**DELEGATED DECISION FOR APPLICATION FOR CERTIFICATE OF
LAWFUL DEVELOPMENT**

Reference no.: 2017/CL/94012/E

Site: 3 Schenro Woodhouse, Shelley Woodhouse Lane,
Shelley, Huddersfield, HD8 8NB

Description: Certificate of lawfulness for proposed erection of
detached garage

DRAWING TITLE
LOCATION PLAN

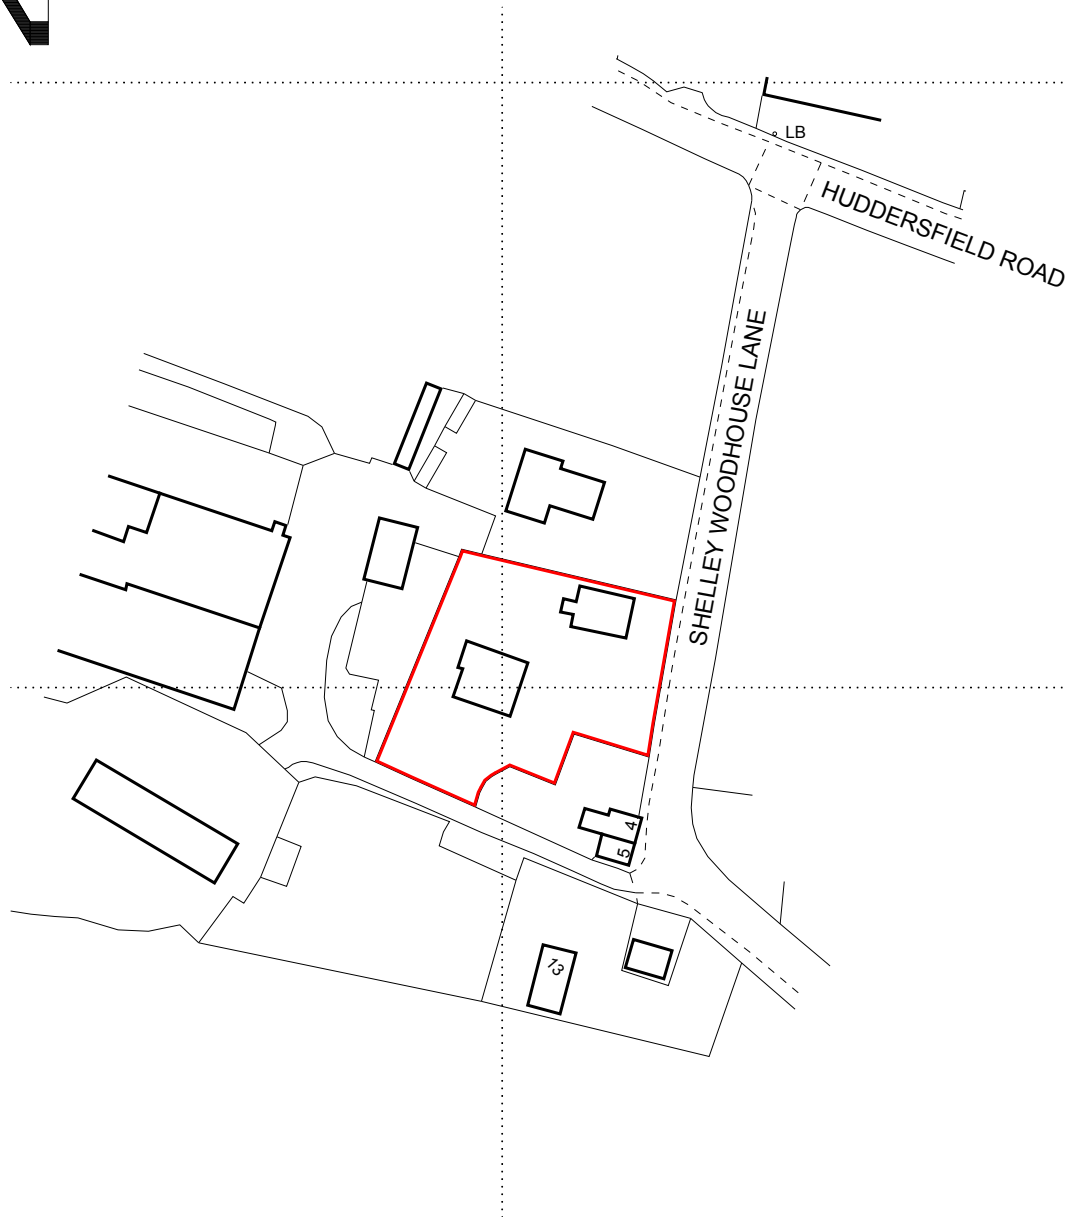
Comment *As can be seen from the location plan provided by the applicant, the proposed outbuilding would not take up more than 50% of the area of the curtilage of the dwellinghouse. Neither are there any other extensions or outbuildings within the site which could be considered to cover more than 50% when considered with the proposed outbuilding.*

Comment *The submitted location plan does show the outbuilding would be built between the dwelling and Shelley Woodhouse Lane. However, the elevation of the dwelling which faces towards the road is not the principle elevation.*

CLIENT MR & MRS M FAIRBROTHER				DRAWING TITLE GARAGE - PROPOSED		
PROJECT 3 SHELLEY WOODHOUSE LANE, SHELLEY		JOB NO 3878	DRG NO 21	REV -	SCALE @ A3 AS	DATE 15 12 17

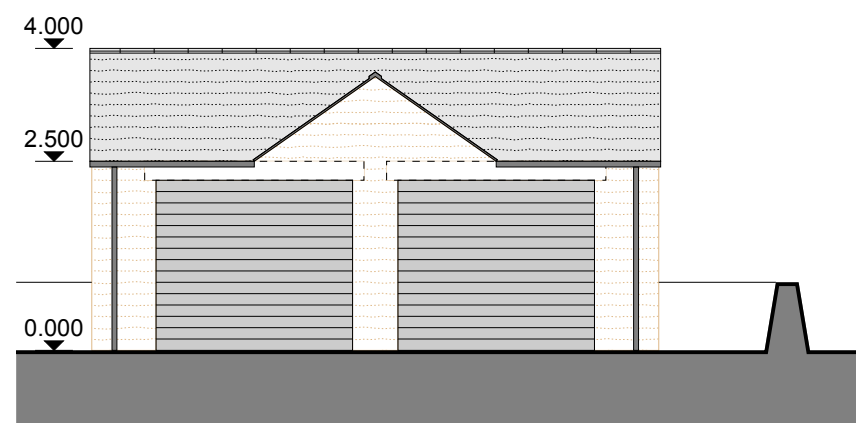
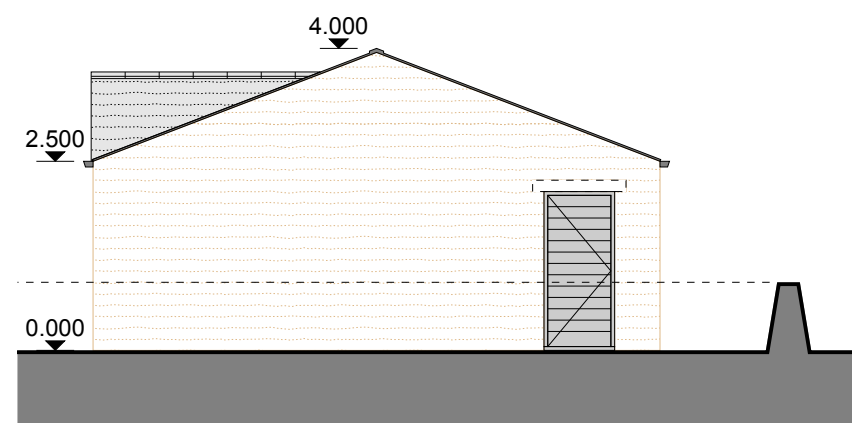
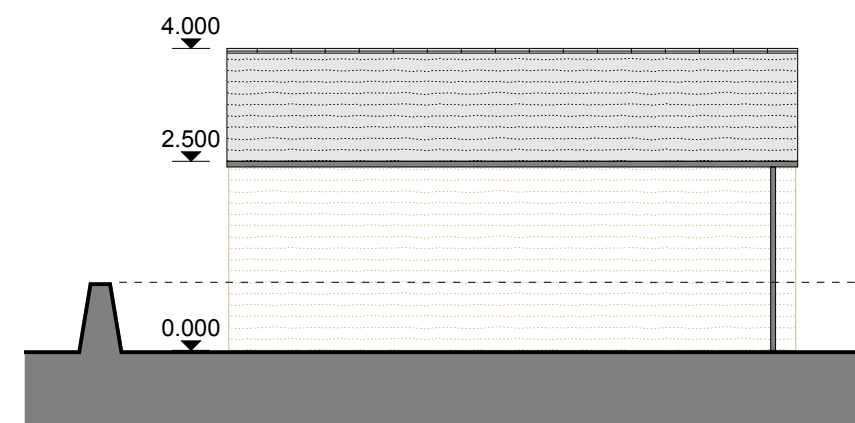
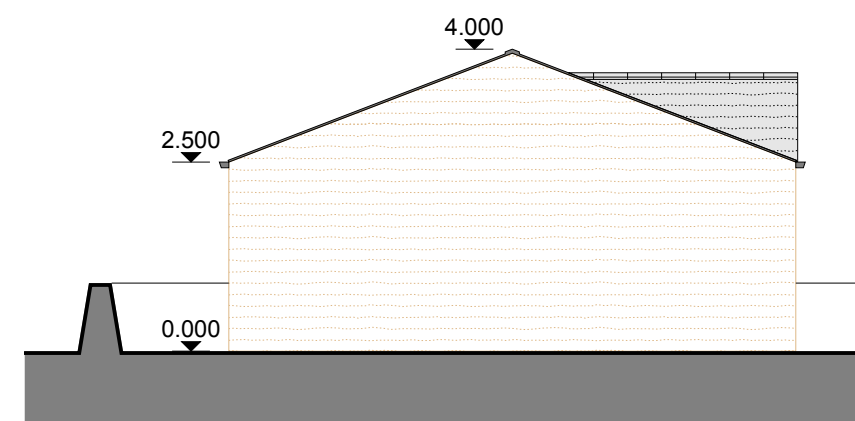
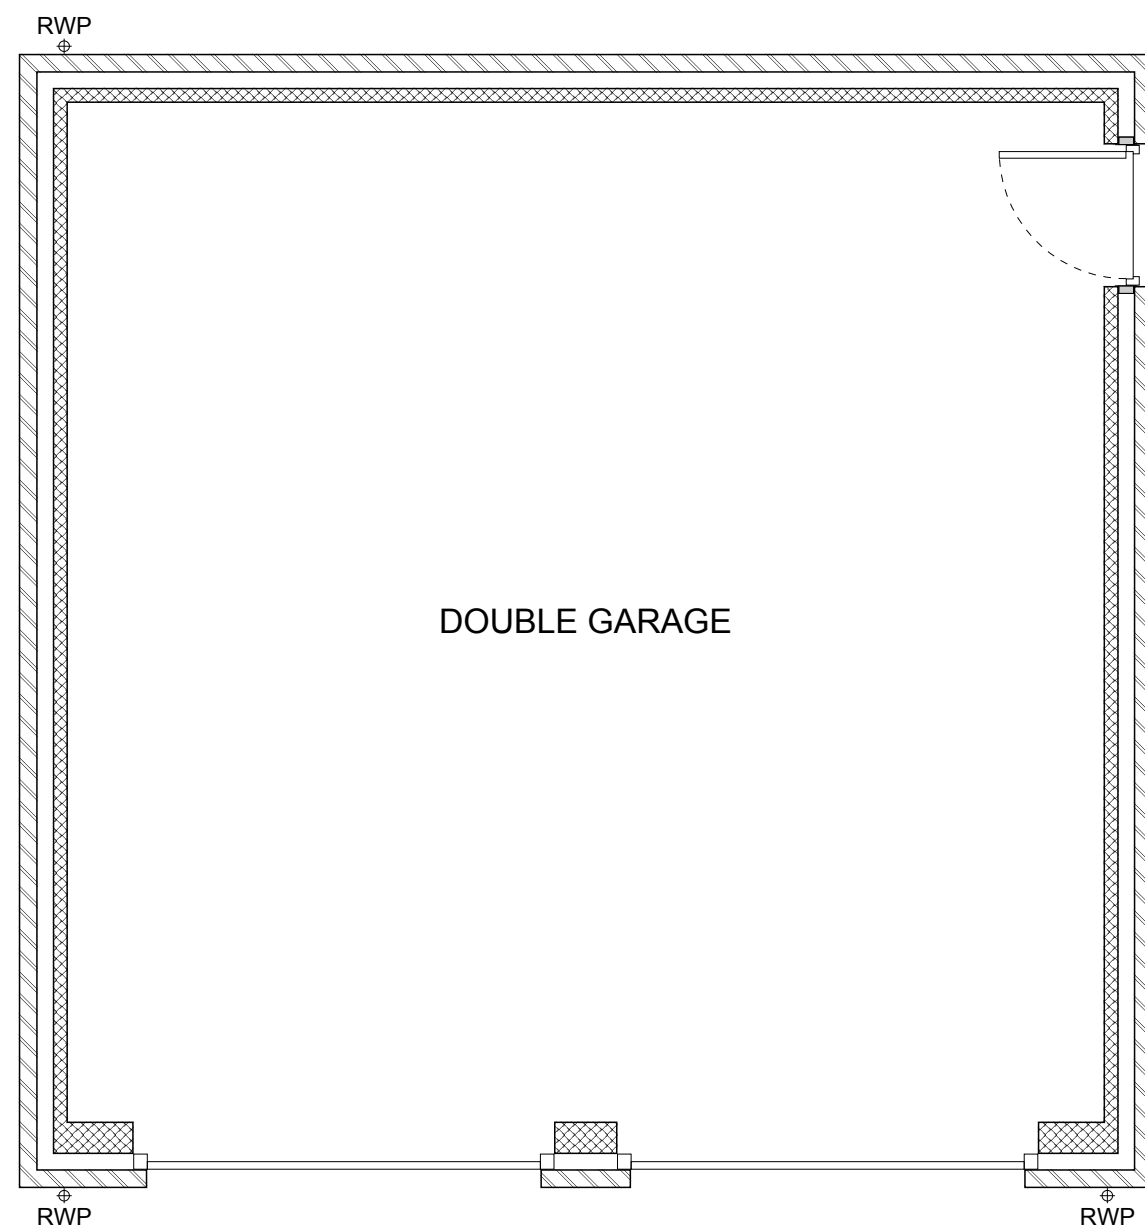
Comment *The outbuilding would have a maximum height of 4m and is located 2m from the boundary of the dwelling.*
- (f)** The height of the eaves of the building would exceed 2.5m;

Comment *The eaves height is shown on plan as 2.5m.*
- (g)** The building, enclosure, pool or container would be situated within the curtilage of a listed building;

Comment *The host property is not listed.*
- (h)** It would include the construction or provision of a verandah, balcony or raised platform;
Comment *the plans do not show any verandah, balcony or raised platform.*
